EPC STORMWATER REVIEW COMMENTS
IN ORANGE BOXES WITH BLACK TEXT

RE: Substantial Compliance
Rex Road Water Quality Pond
Rolling Hills Ranch North Early Grading Permit
Grading Plans Approved June 15, 2022

January 27, 2026

TECH CONTRACTORS 11910 TOURMALINE, #130 FALCON, CO 80831 TELEPHONE 719.495.7444	
RUNOFF REDUCTION CATCHMENT AREA B ROLLING HILLS RANCH NORTH PUD	
Scale 1"=40'	Drawn by TAK
Sheet Number 2	Checked by -
Date JAN 2024

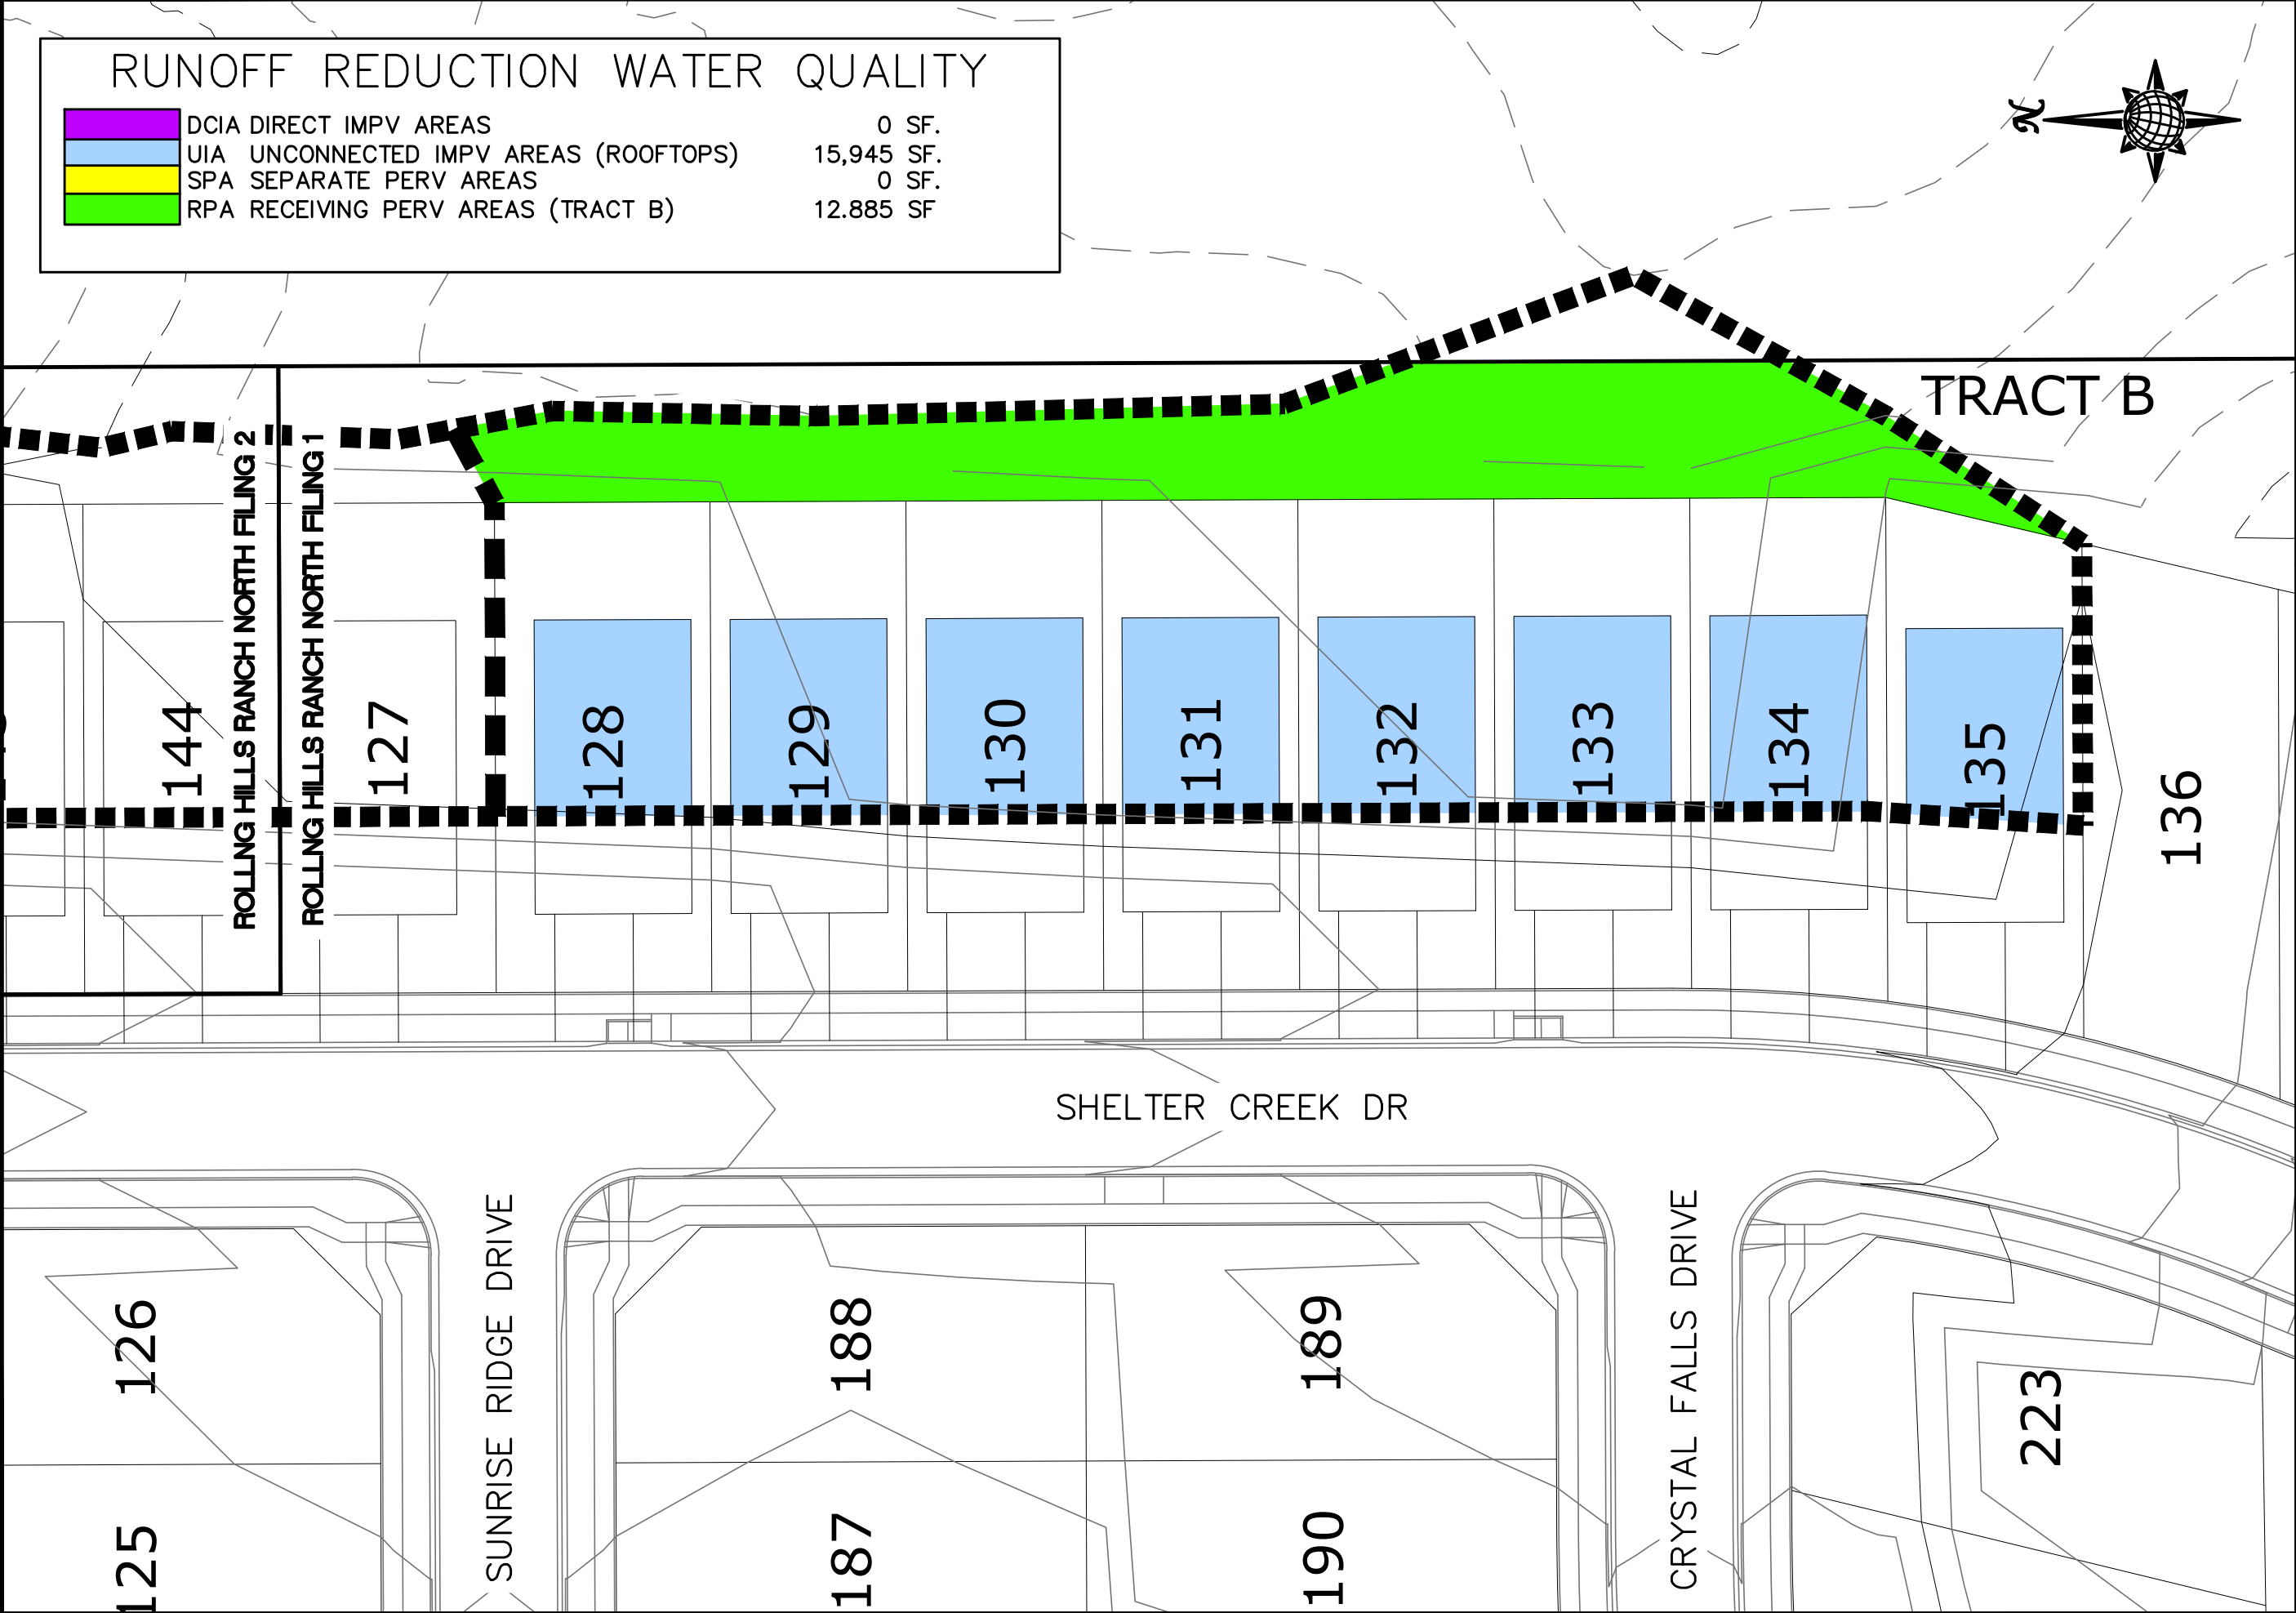
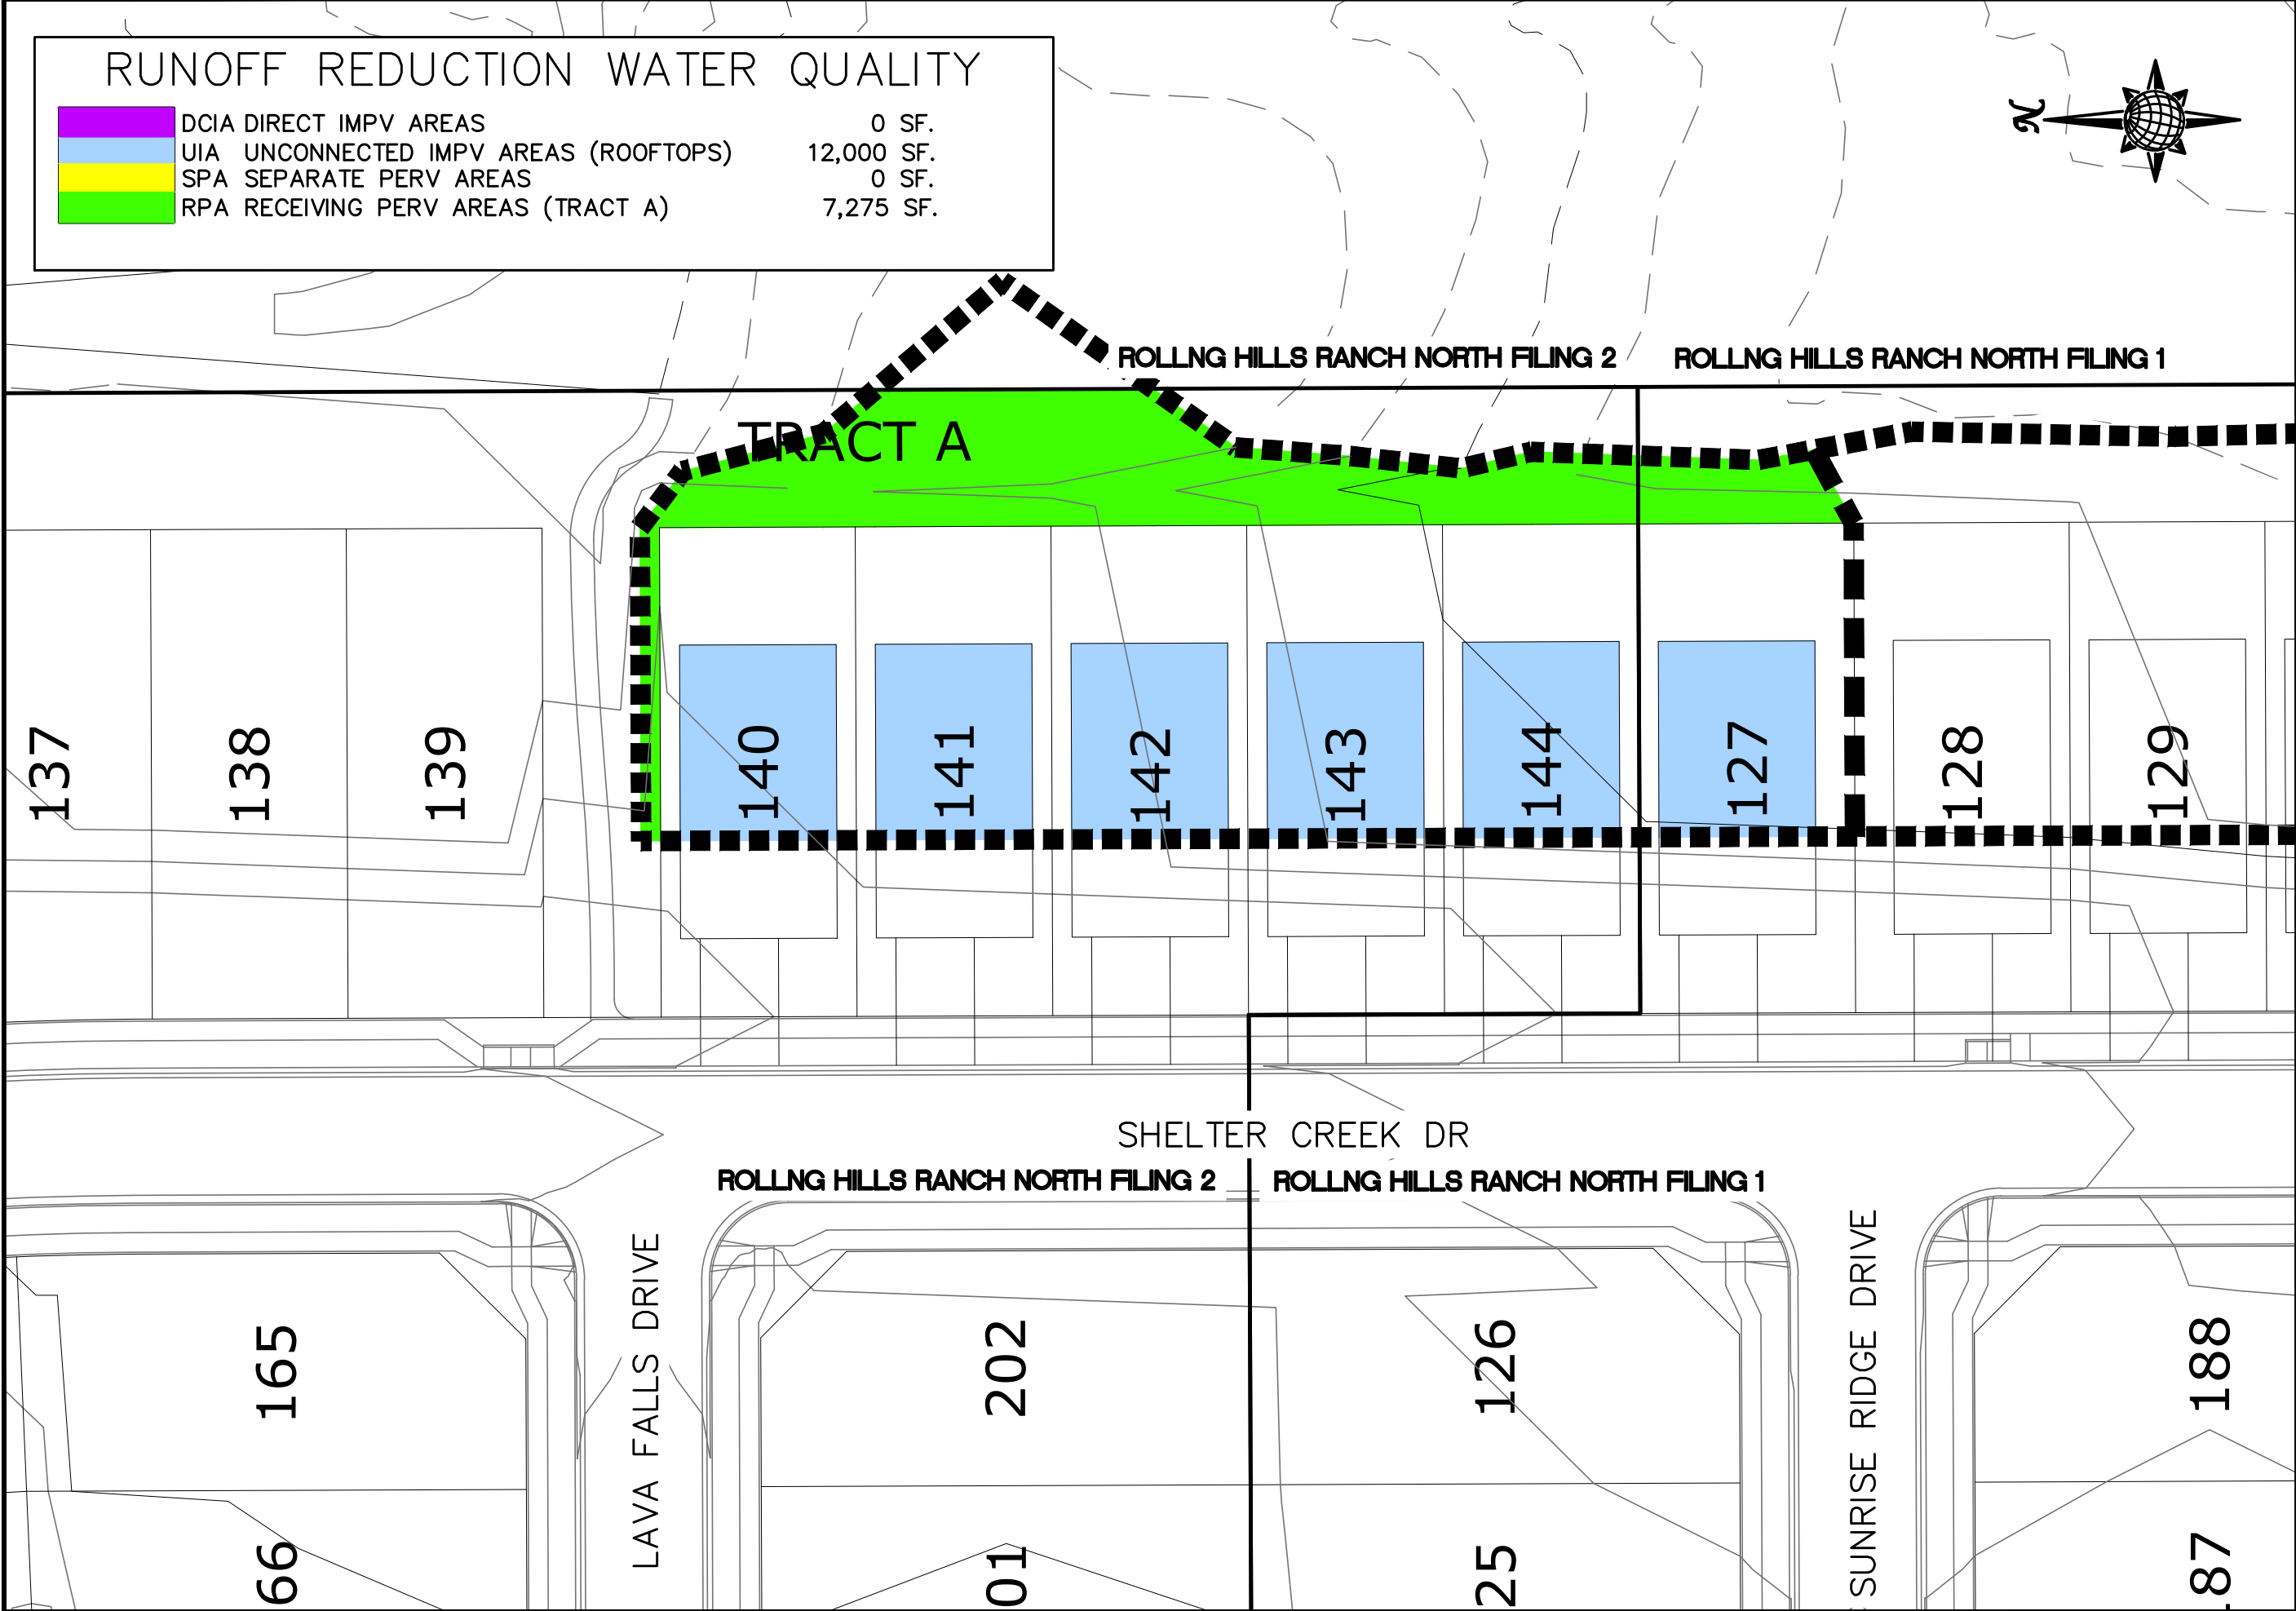
This PCM Certification letter should include cert of the runoff reduction areas. The WQ pond was not technically built under this SF so it is not needed but if you would like to keep it, that is fine it does not need to be removed.

Please include short discussion verifying the RPA area meets/exceeds the design (in regard to dimensions, veg cover, slope, etc) and include design calcs with no revisions if no field changes occurred (per the as-builts and field conditions it does not appear they have).
